RE: Napper Tandy's

A plan review was received by this office concerning the construction of the above referenced facility. The plans and specifications are approved with the following comments:

New Floor Plan

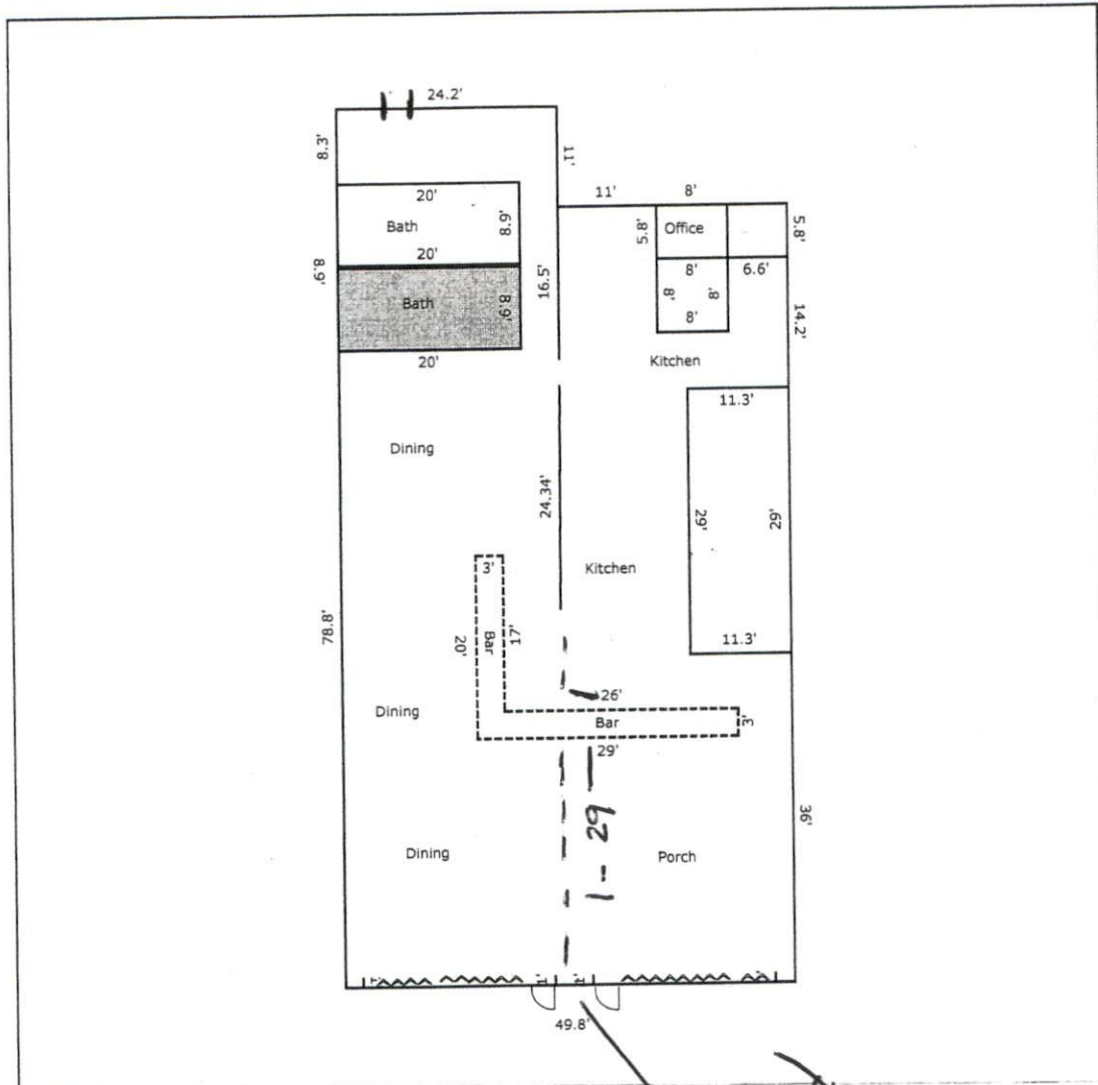
-Due to open dining concept utilizing large garage door style openings on the exterior wall, the doors to the main kitchen area shall comply with 6-202.15 Outer Openings, Protected of the North Carolina Food Code Manual.
